From: Hannah Riddle on behalf of Planning.Responses
Sent: 09 March 2022 16:13
To: Planning Scanning
Subject: FW: WA/127/21/OUT

Please find attached the amended layout plan and the updated Ecology Mitigation and Enhancement Statement for **WA/127/21/OUT** for Land West of Tye Lane, Walberton.

Please could you confirm the precise area in hectares that would be occupied by formal and informal public open space, and the precise area in hectares that would be occupied by play space in WA/127/21/OUT, this information has not been provided in the Design and Access Statement?

Drawing Title:
SITE LAYOUT
LOCATION PLAN

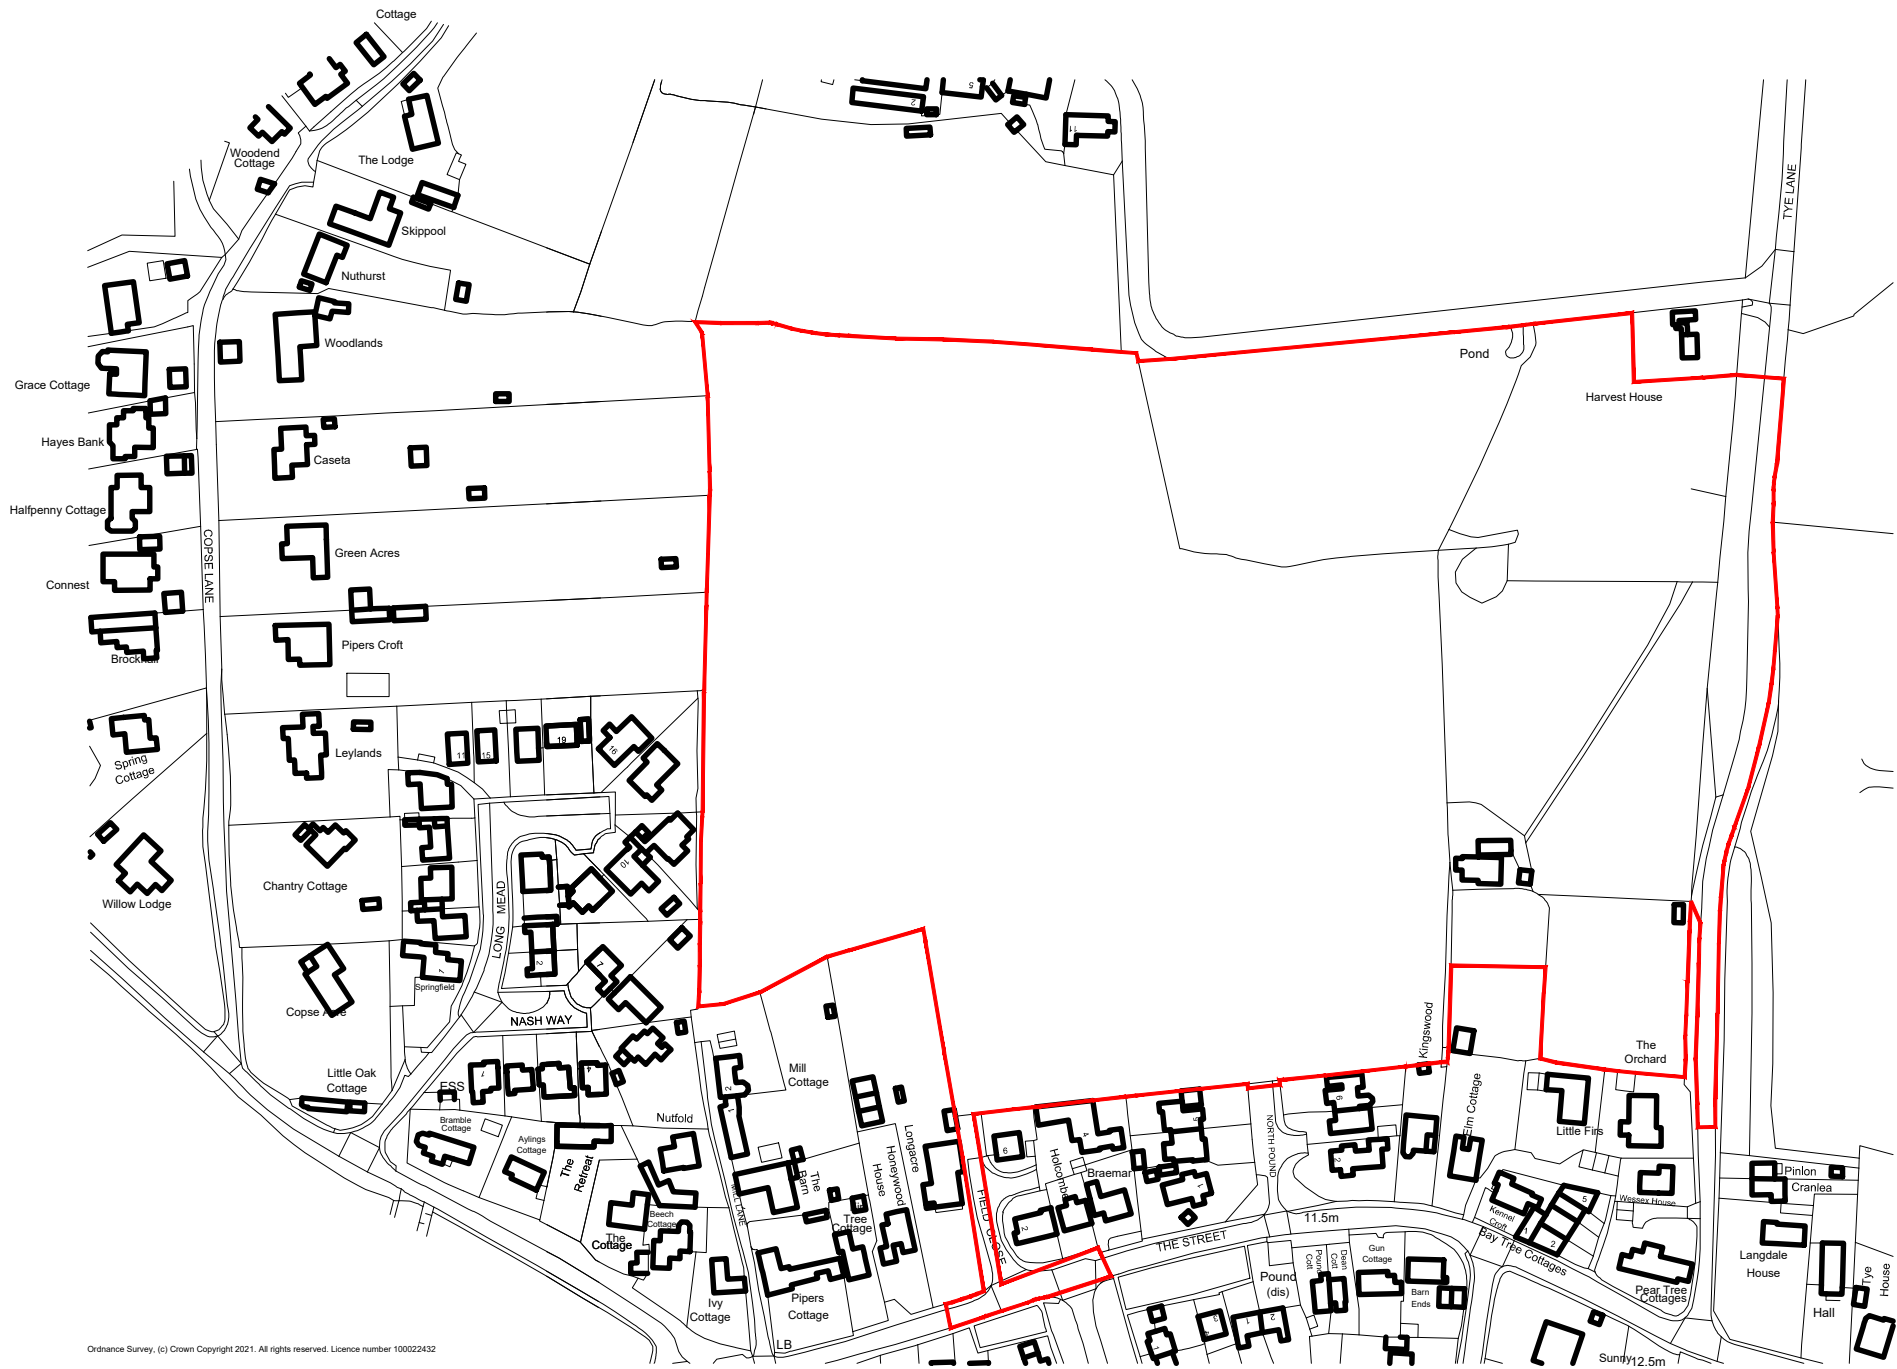
The updated Ecology Mitigation and Enhancement Statement detailing a dark corridor round 'Field 1' (Figure 15) is suitable. The site plans should be updated to show the dark corridors. Conditions should be used to ensure this.

When will the amended layout plan be submitted which will include the provision of an emergency vehicle access from the south; together with a footway/cycleway and green infrastructure surrounding the entire site?

In terms of the updated layout. This is attached and shows the emergency access to Field Close and a 10metre dark corridor on the western boundary, in line with the updated Ecology Mitigation and Enhancement Statement also attached.
